Your Ref: **32111000**
Our Ref: **G pre00220/2019**
(Please quote in all related correspondence)

Re: Scoping Document for proposed replacement of 7 manned level crossings between Limerick Junction and Cork City on the Dublin-Cork Railway line.

Re: Replacement of 7 manned level crossings at Limerick to Cork Line.

Title: Interpretative Plan of Geophysical Survey Results, Newtown

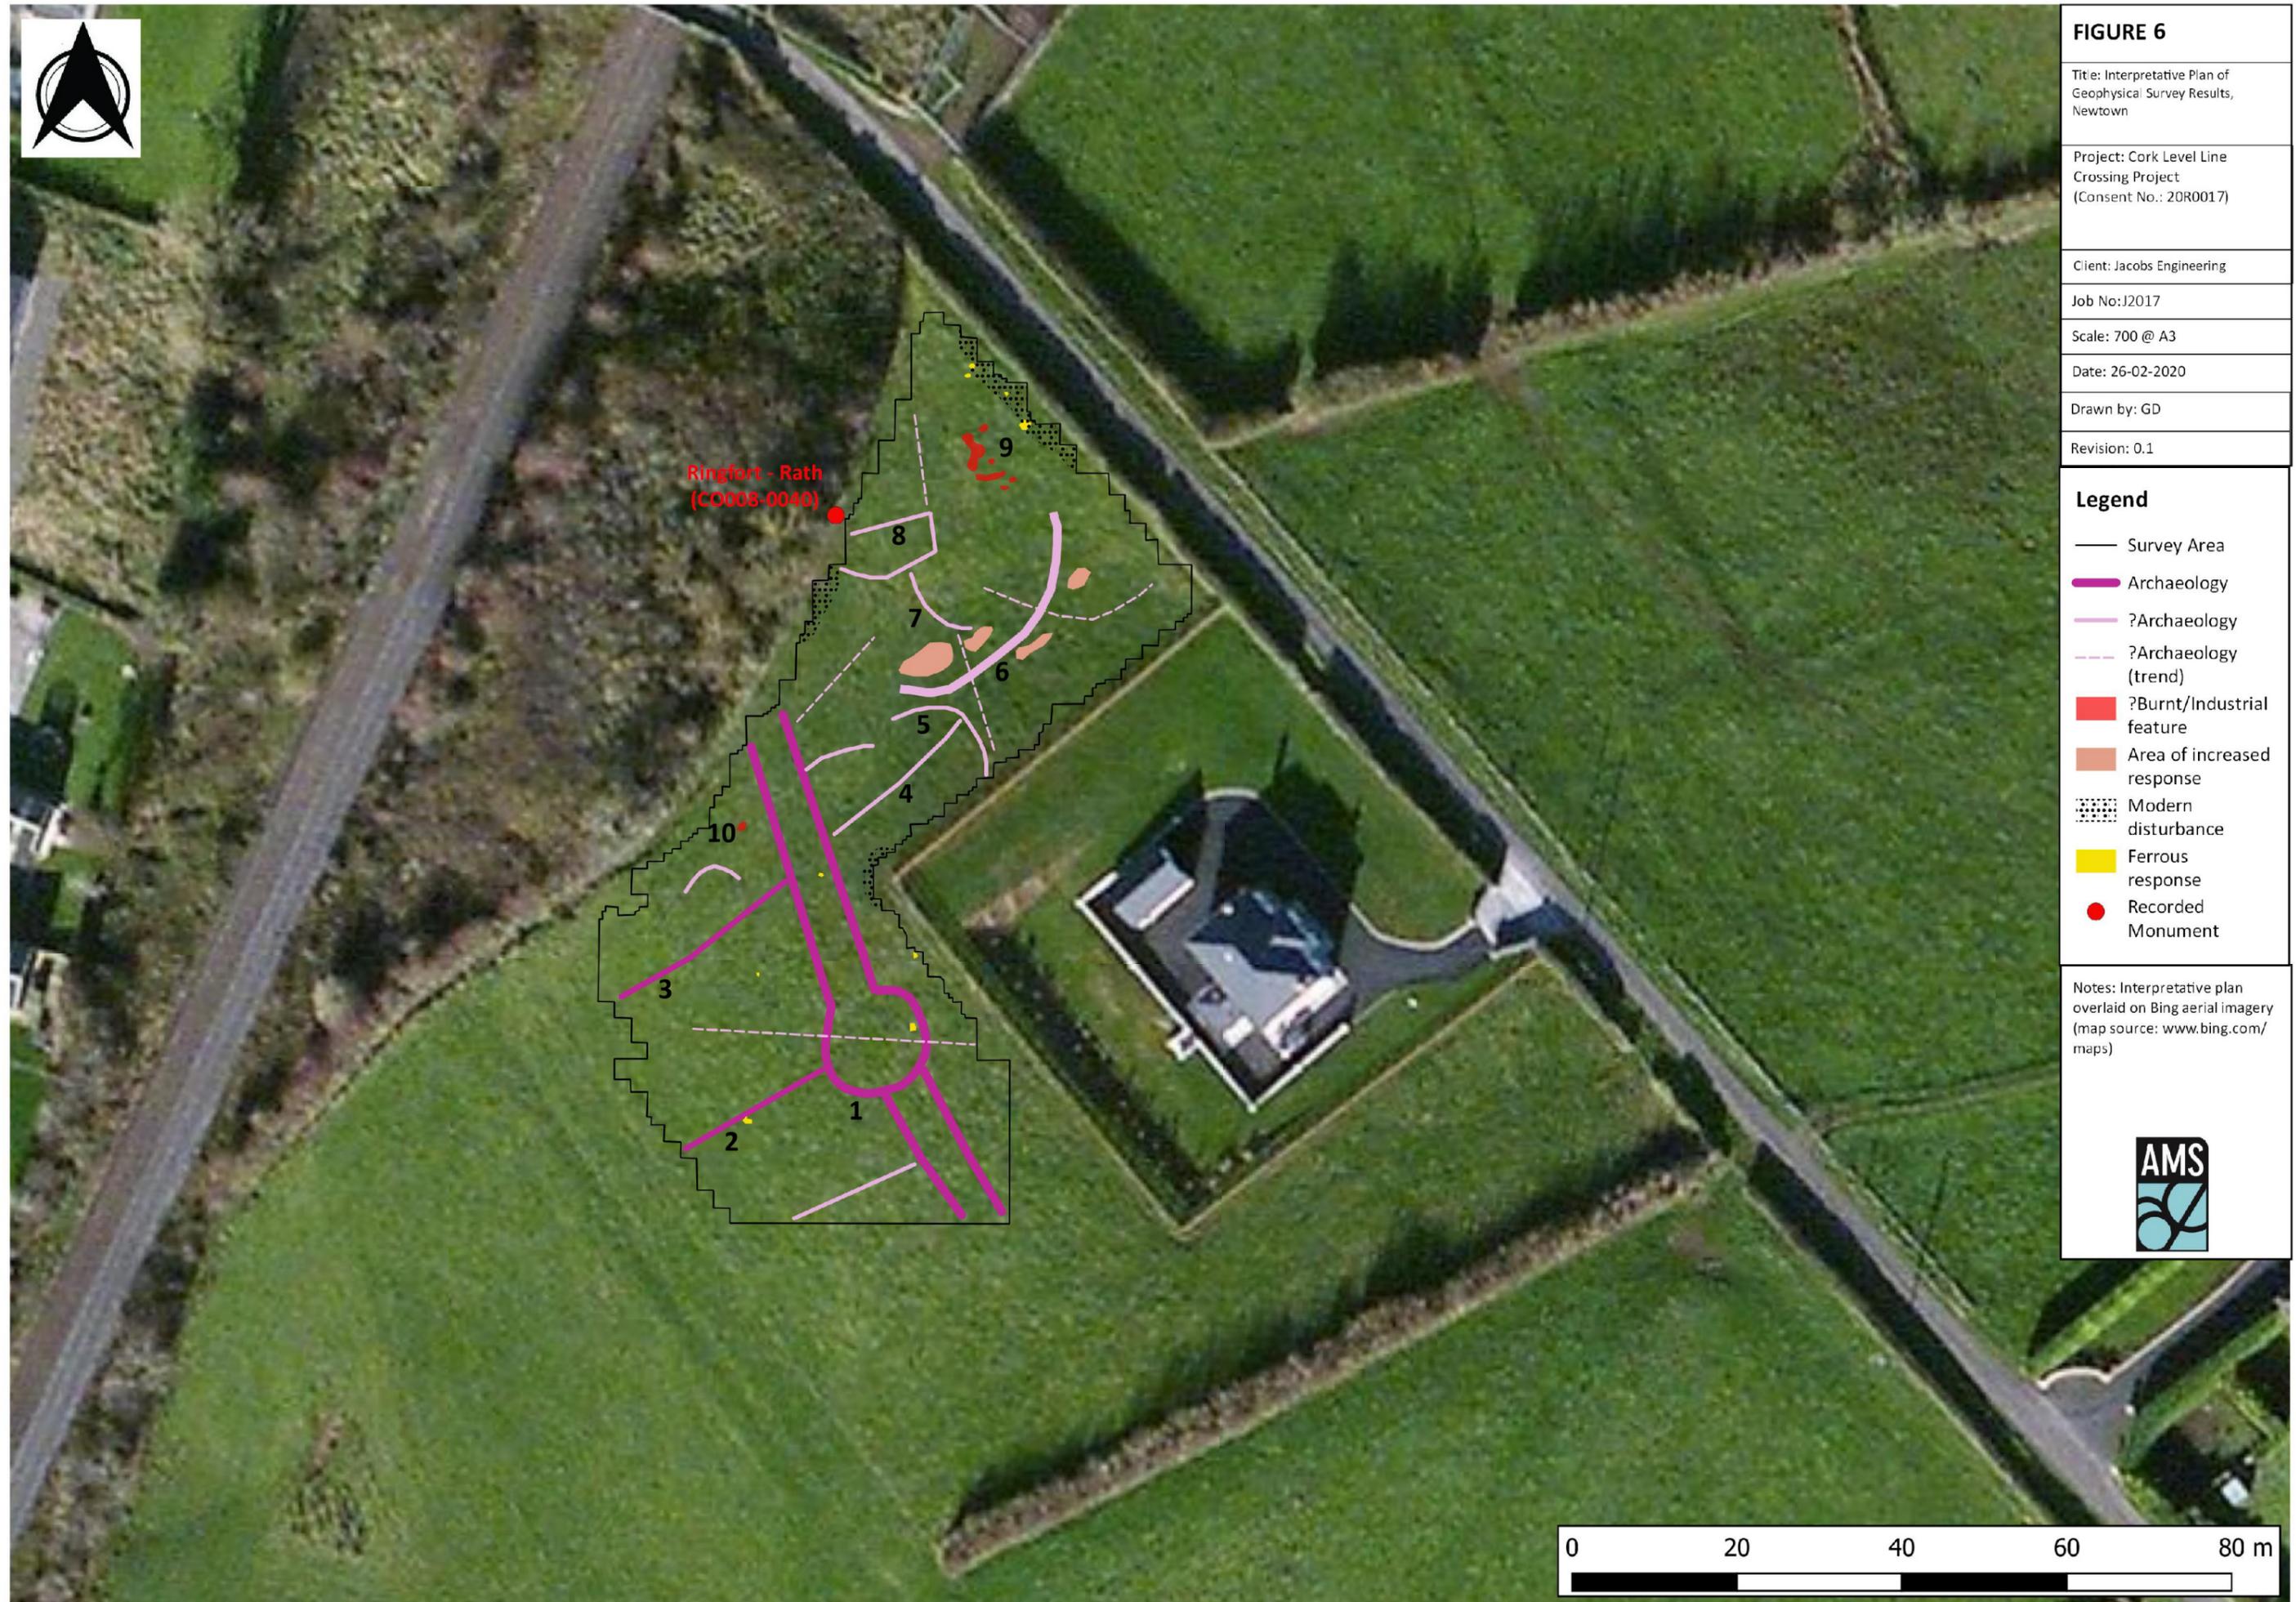
As noted in the report 20R0017 Newtown a number of subsurface anomalies were recorded in the vicinity of Recorded Monument CO008-040--- *Ringfort*. These anomalies may represent archaeological features/deposits associated with this monument. Archaeological mitigation in this regard is now outlined below.

2. A programme of targeted archaeological test excavation, based on the results of the geophysical survey, is required at Newtown, Co. Cork in order to establish the location, nature and extent of archaeological features/deposits recorded.

Title: Interpretative Plan of geophysical survey results, Imphrick

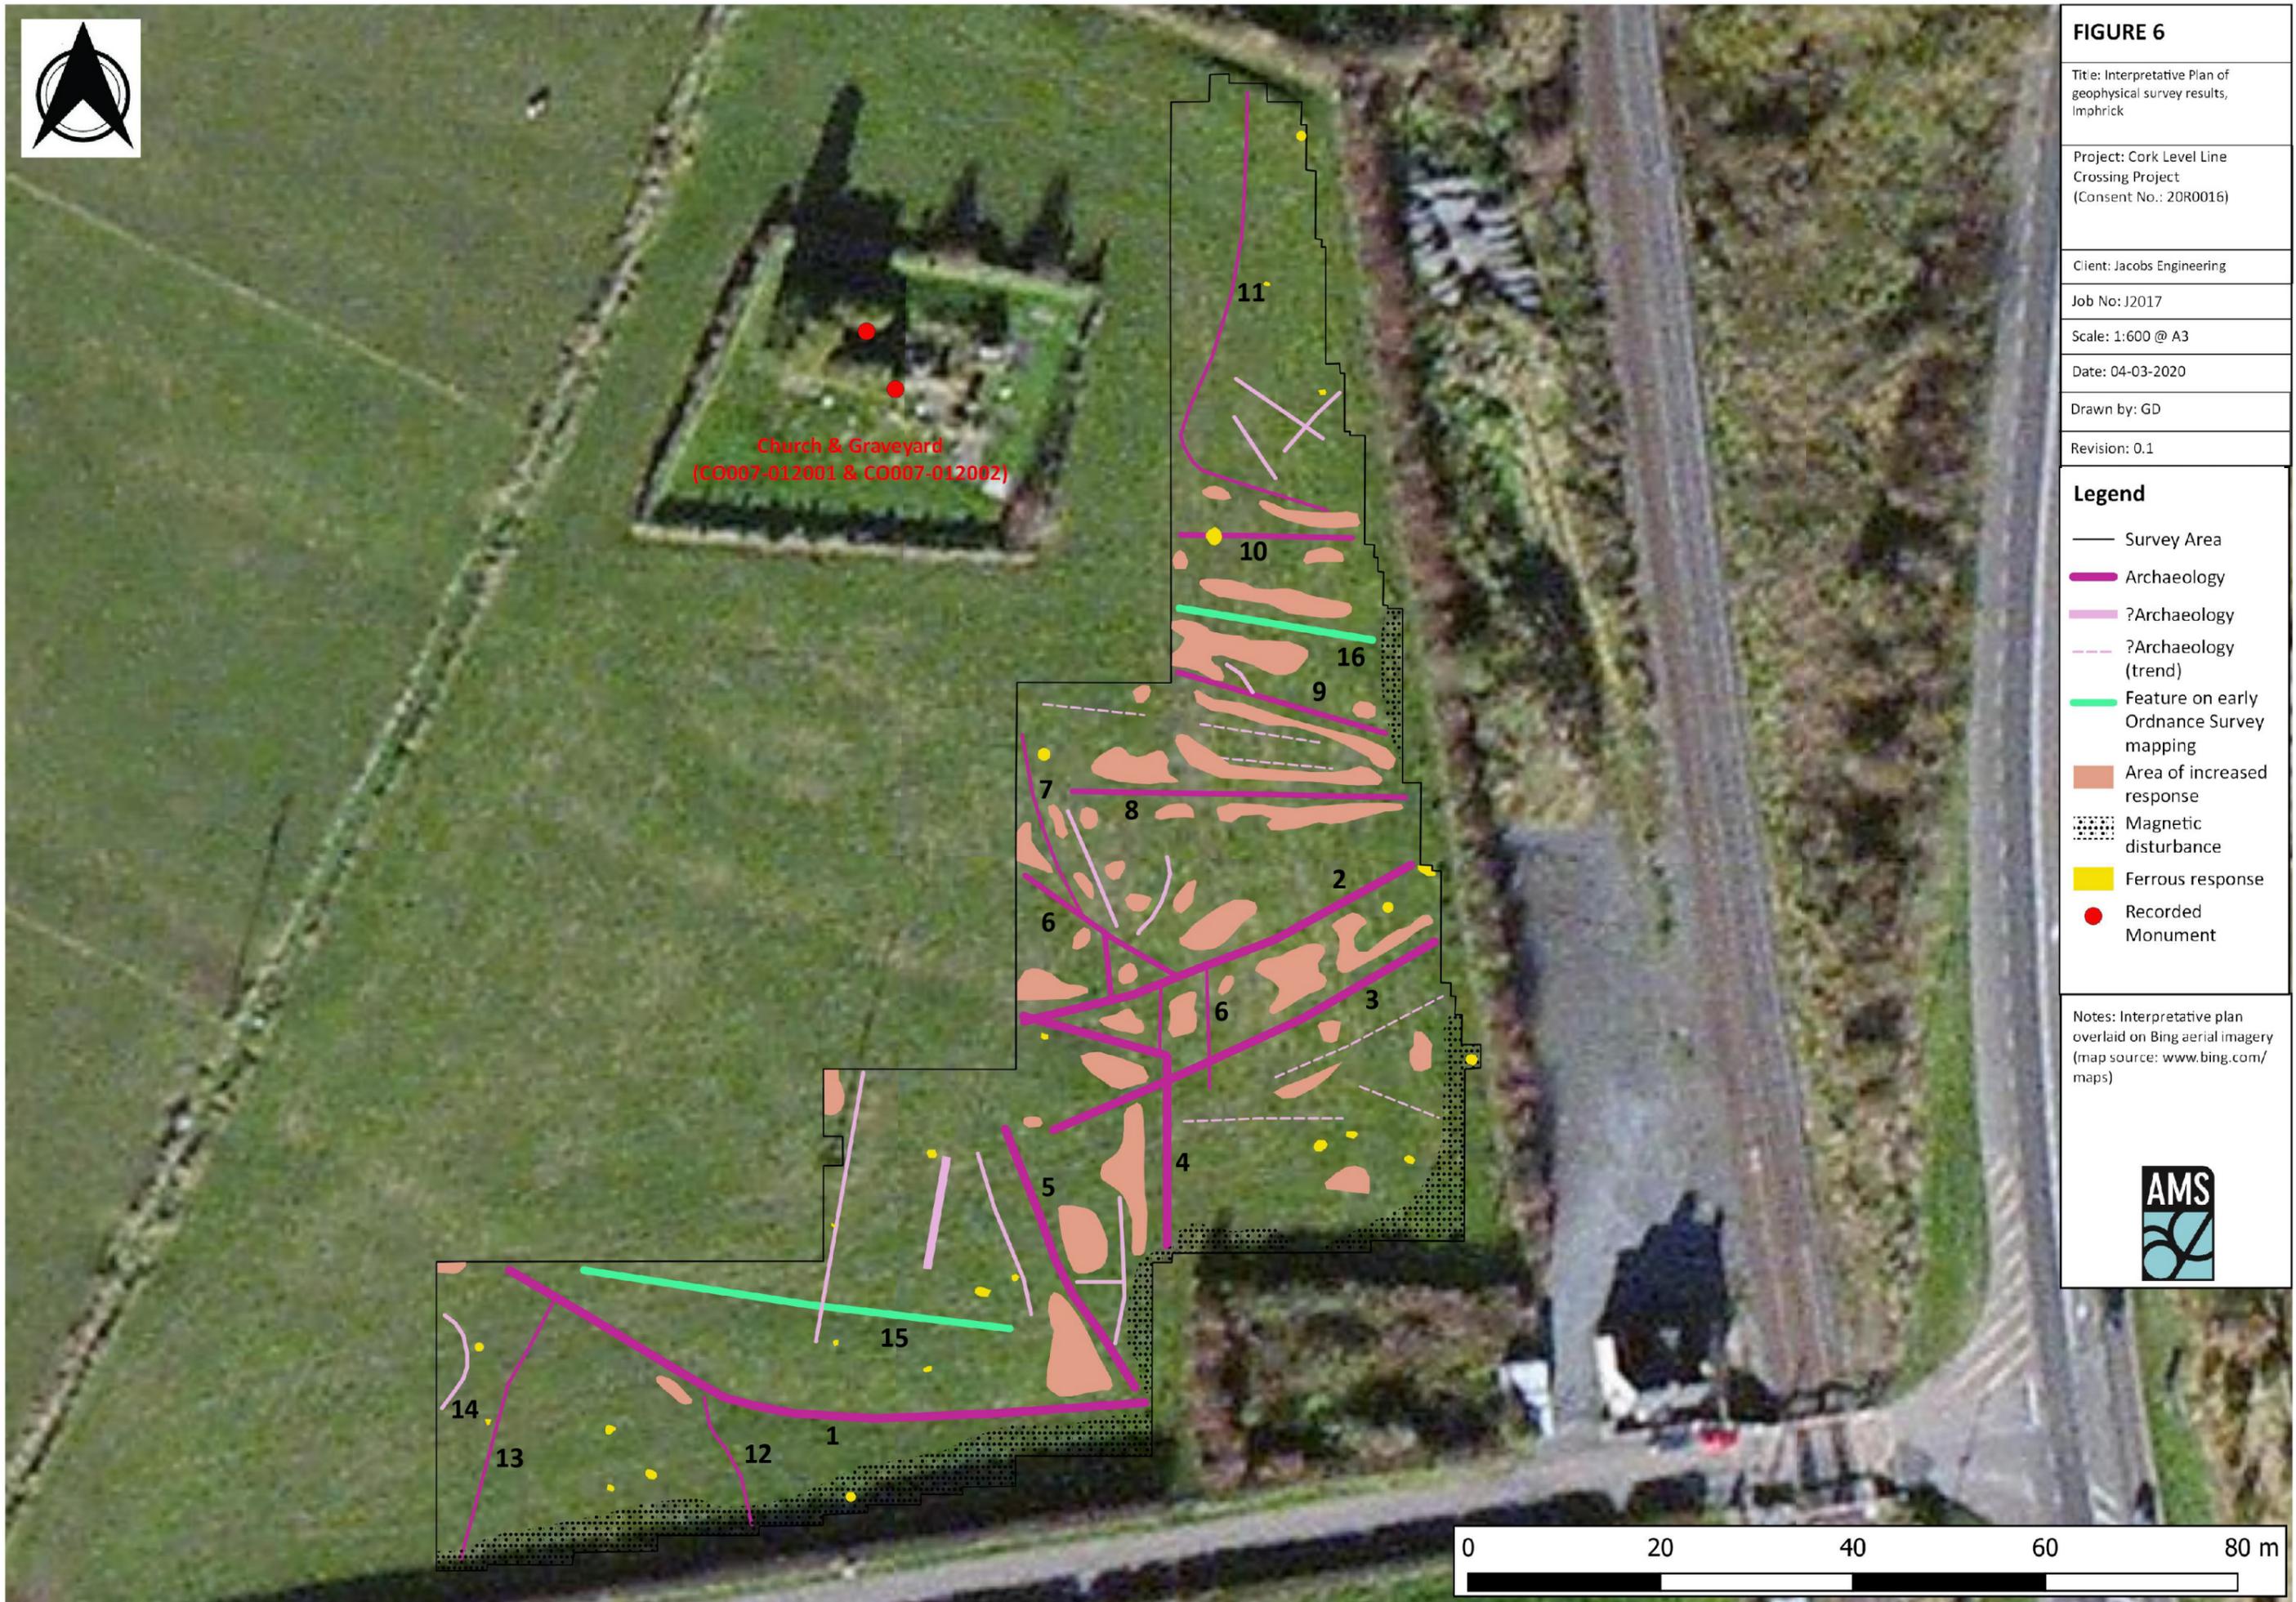
Report 20R0016 Shinanagh/Imphrick has recorded extensive and possibly archaeologically significant anomalies to the E/SE/S of Recorded Monument CO007-120(001-/002) *Church and graveyard*. Geophysics to the north of this monument has recorded a circular enclosure with extensive and possibly significant features within it – possibly representing a hut-site/souterrain/area of burning. There are also a number of features/low earthworks surrounding the enclosure itself.

A site inspection carried out on 02-07-2020 revealed that the earthworks in the vicinity of CO007-120, in addition to the newly recorded enclosure and its' associated features, all have surface expression at present ground level. Furthermore, the enclosure is clearly

visible as an upstanding scarped monument ranging in height from c. 40-70/80cm enclosing an area approximately 50/60m in diameter. Archaeological mitigation with regard to these monuments/features is also outlined below.

3. Given the extensive and possibly significant archaeological earthworks/features, including a newly recorded upstanding enclosure, at Shinanagh/Imprick, a programme of targeted archaeological test excavation is required. This will establish the location, nature and extent of archaeological features/deposits revealed during geophysical survey and field survey. In particular the nature of the earthworks to the E/SE/S of RMP CO007-120--- needs to be established in tandem with the newly recorded enclosure and its' associated features.
